Submission Form

Epping to Thornleigh Third Track Proposal. Application number SSI 5132.

I/we object to the Epping to Thornleigh Third Track Proposal and consider that the EIS is inadequate and does not address the full impact of this proposal. It will cause untold damage to the health of residents and to the fabric of the Beecroft Cheltenham Heritage Conservation Area. Do not approve this project, reconsider the alternatives and protect the community.

Figure S.3 Cross-section and elevation - New Cheltenham Station concourse building

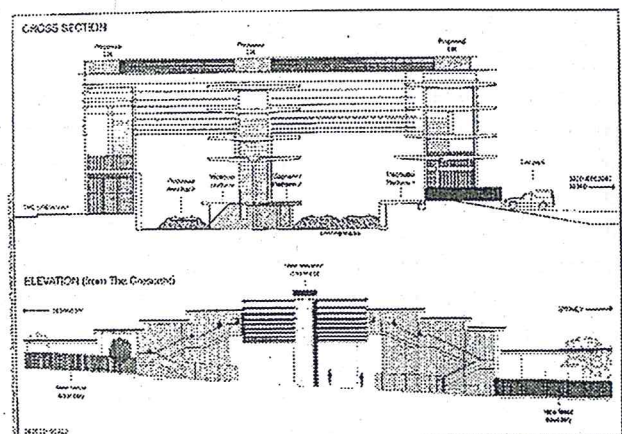
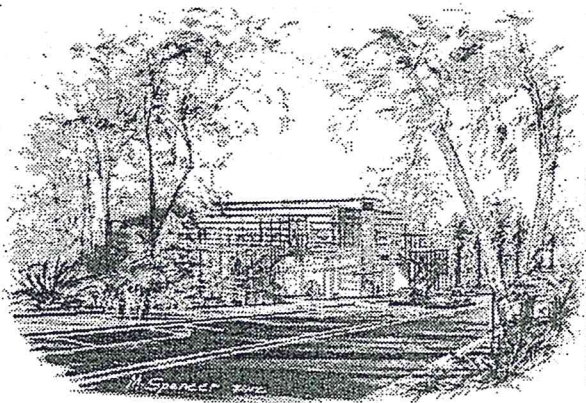
- The proposed redevelopment of Cheltenham Station shows no regard for the HCA. The visual impact of the proposed 13m high glass and steel concourse is totally unacceptable in this HCA.

Figure 5.3 Future Cheltenham Station layout

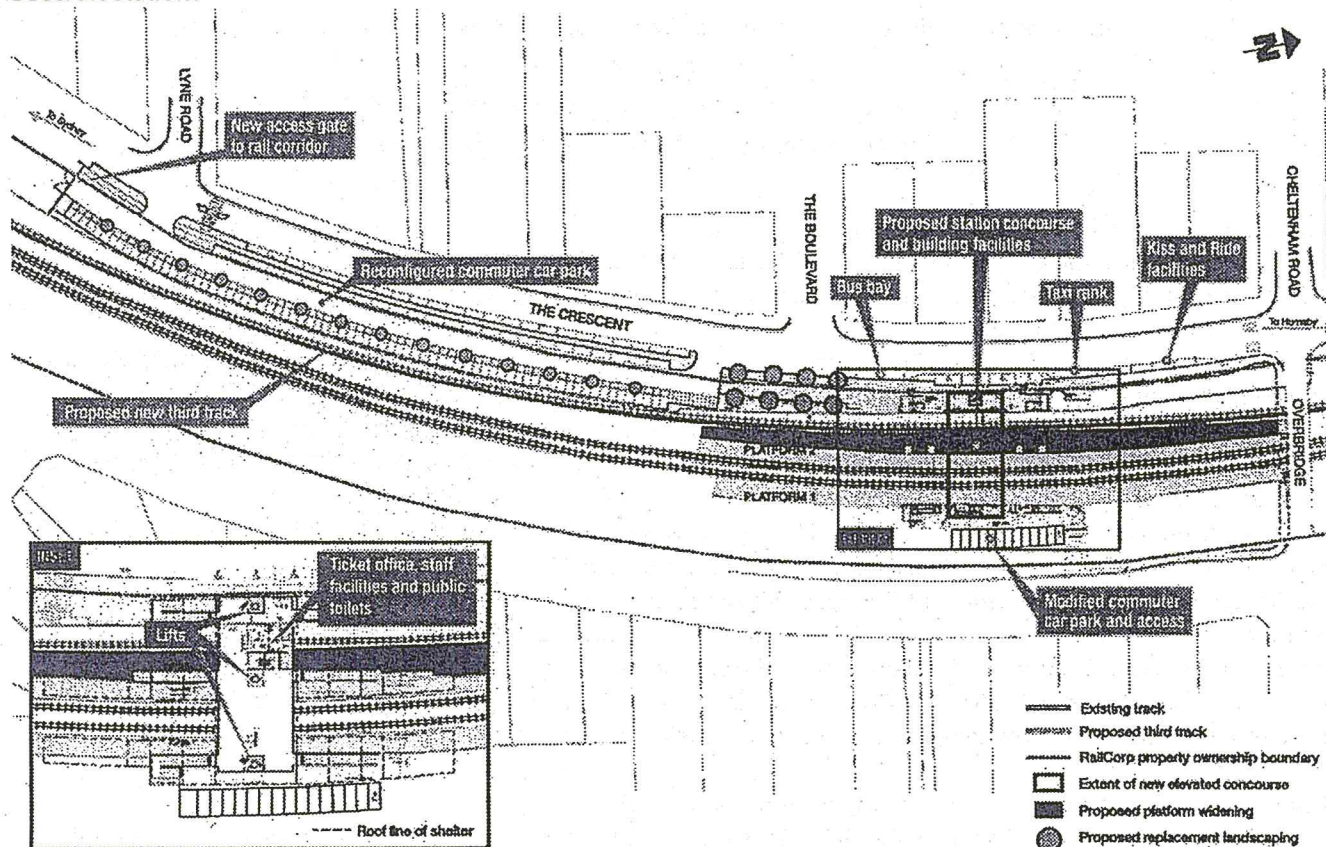
- There has been inadequate assessment of the project's impact on the fabric of the Beecroft Cheltenham Heritage Conservation Area (HCA).
- The plan given for Beecroft Railway station Precinct is vague. The relationship to the trees, playground and original 1895 platform located south of the present station is not shown. A fourth track is shown on the eastern side. The plan does not include urgently needed lifts to allow disabled access at Beecroft Station.
